# CITY OF ALBUQUERQUE

**RE: Lobo LL Field Expansion at Balduini Park**  
**Grading Plan**  
**Stamp Date: 8/7/17**  
**Hydrology File: H16D149**

Re: Lobo LL Field Expansion at Balduini Park  
Grading Plan  
Stamp Date: 7/13/17  
Hydrology File: H16D419

On July 18, 2017, I received a letter from you regarding your review of the Grading Plan for the Lobo Little League Field Expansion at Balduini Park. Your original comments are listed below (in italics), followed by a description of the changes made to the plans.

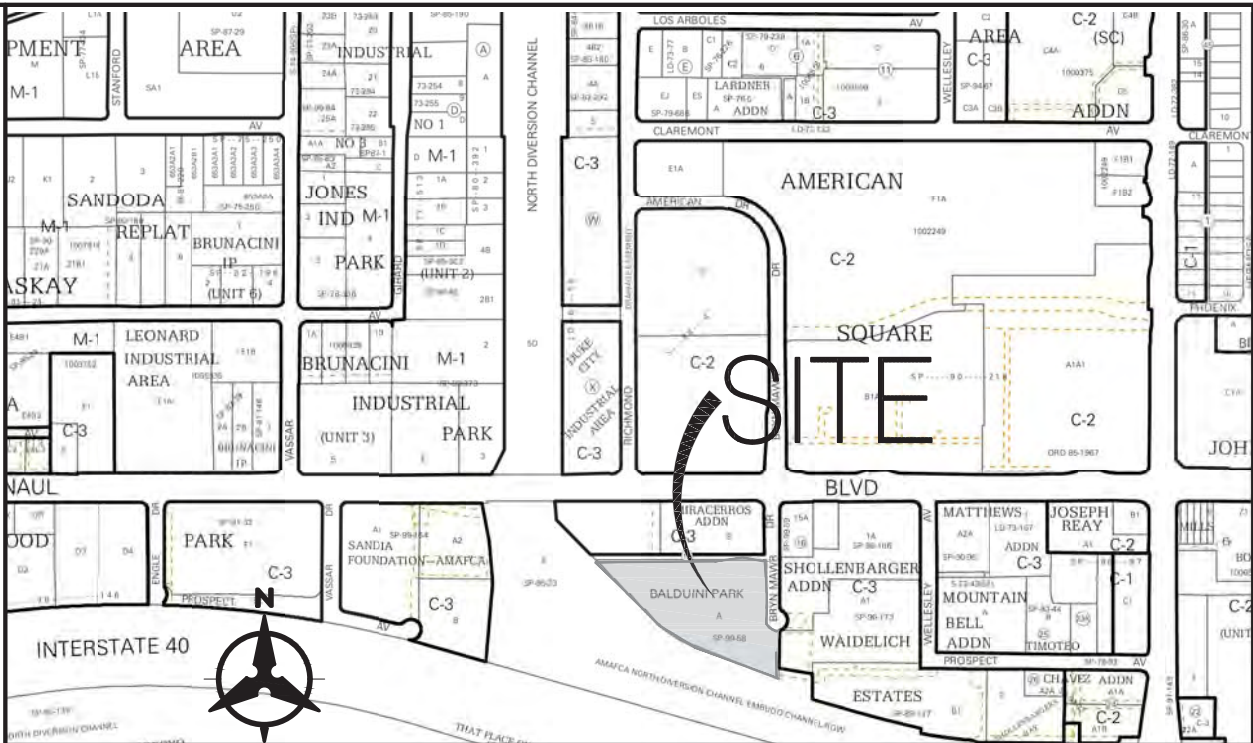
2. *Please provide the floodplain note on the Grading Plan.*

Response: Rudy Rael's note, "NOTIFY THE COA FLOODPLAIN ADMINISTRATOR IN 25% INCREMENTS OF JOB PRODUCTION AND AT FINAL COMPLETION," has been added to the Title Sheet as General Note 12.

LOBO LL FIELD EXPANSION AT BALDUINI PARK
GRADING PLAN

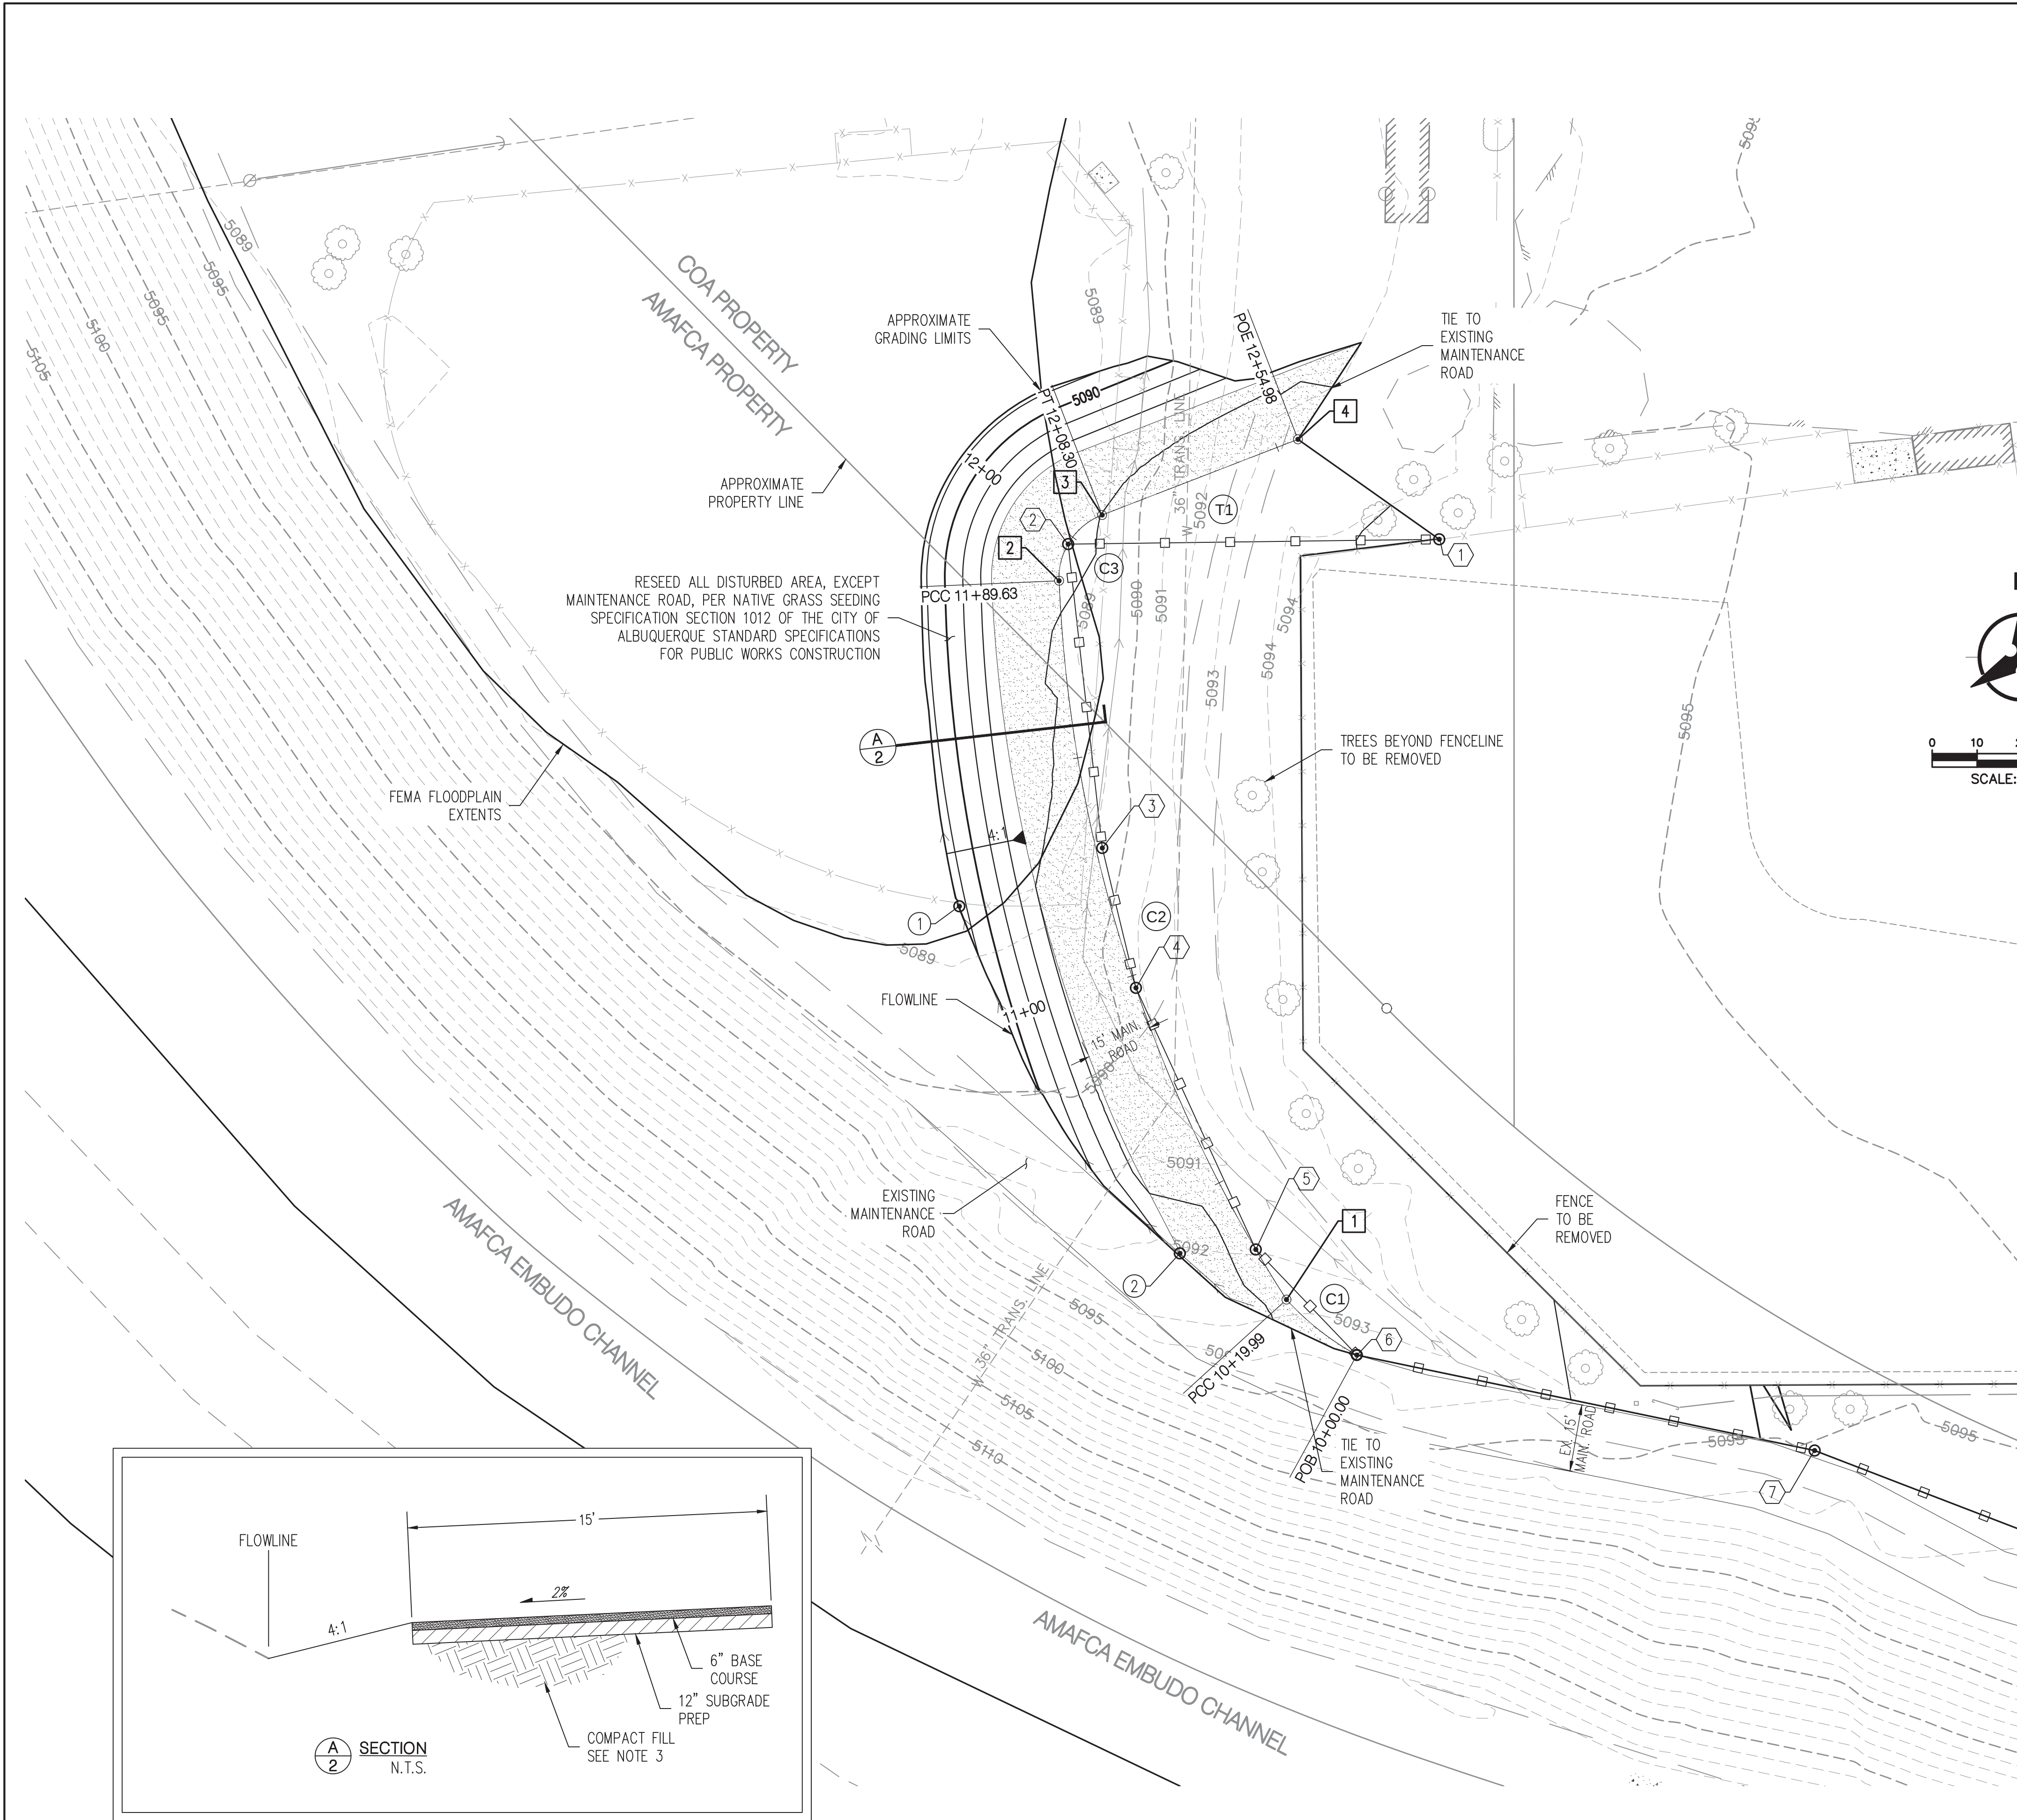
3. *Please label and show the delineation of all floodplain zones within the Grading Plan. Please also include the 100 year flood information for Zone "AH".*

Response: The floodplain for the Embudo Channel was labeled and the information on Zone AH was added to the Grading Plan.
